# Rezoning Transportation Analysis

Petition Number: 2023-015

## Revision Log:

Date	Description
5-24-23	First Review (JT)
10-26-23	Second Review (JP)

RZ - 100

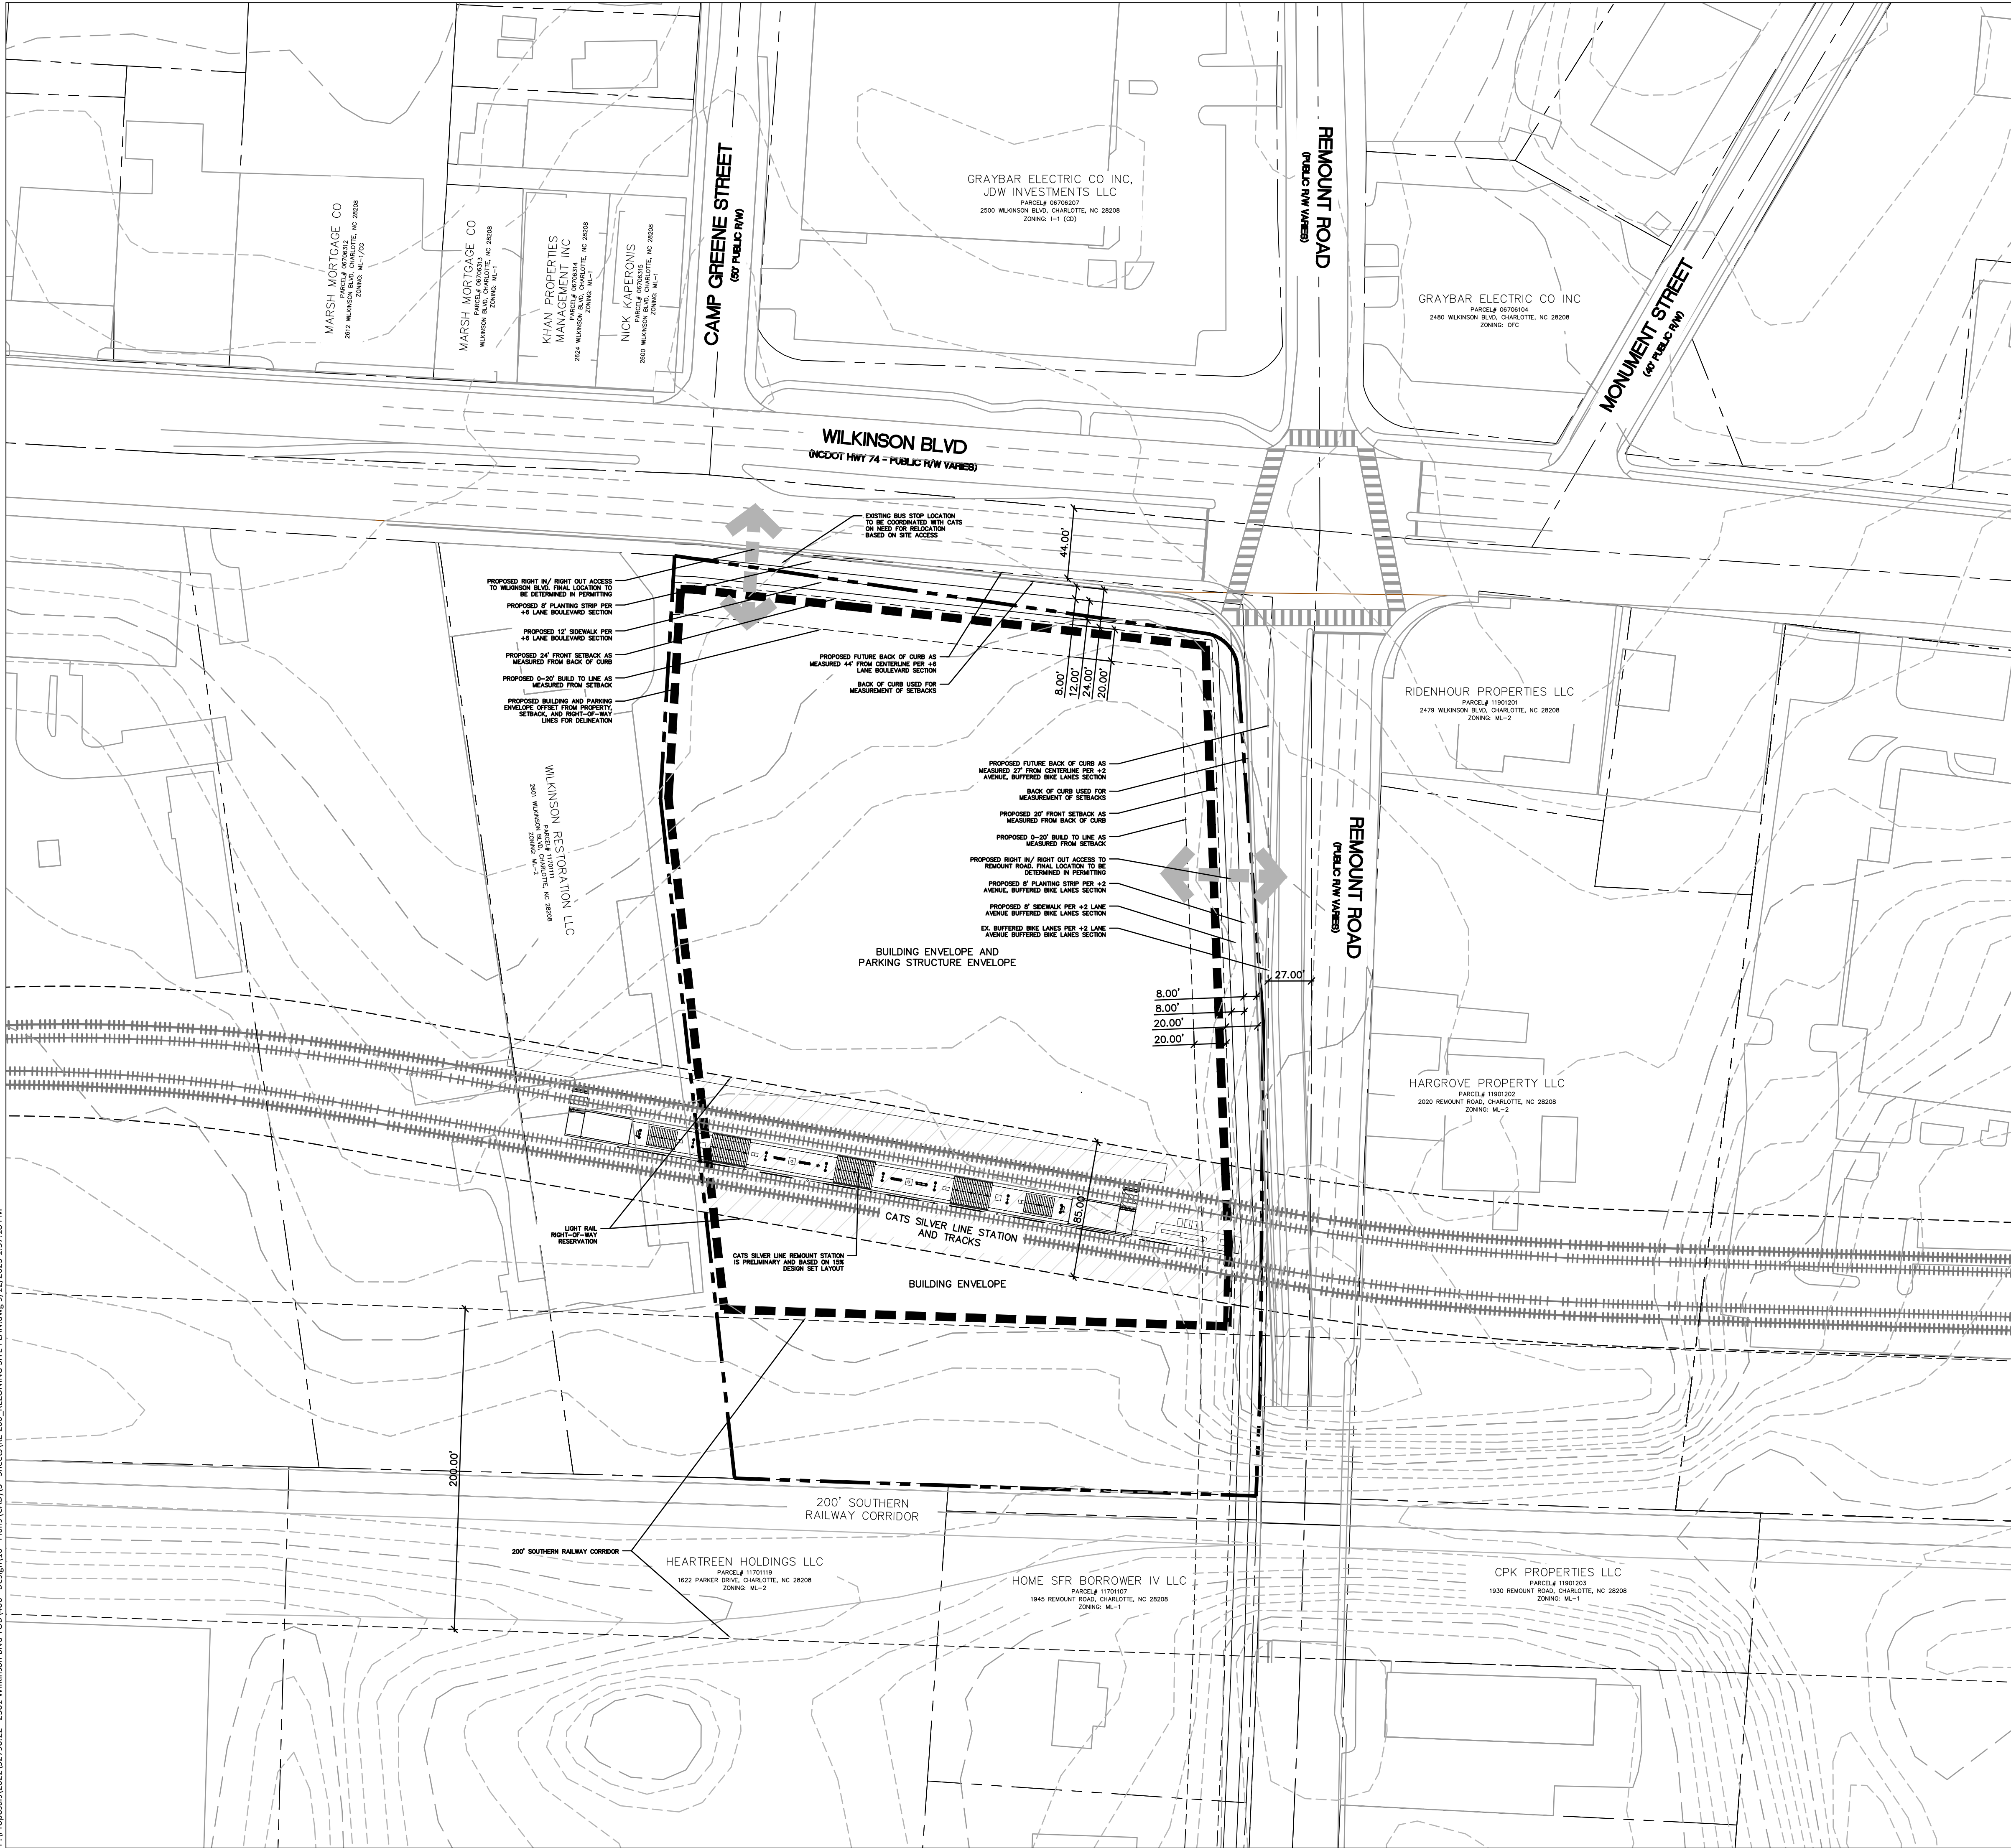
### 1. Curbline:

- Wilkinson Boulevard:** the future location of curb and gutter is in its existing location.
- Remount Road:** the future location of curb and gutter is in its existing location.

Label and dimension the curb and gutter from the centerline for each road on the site plan.
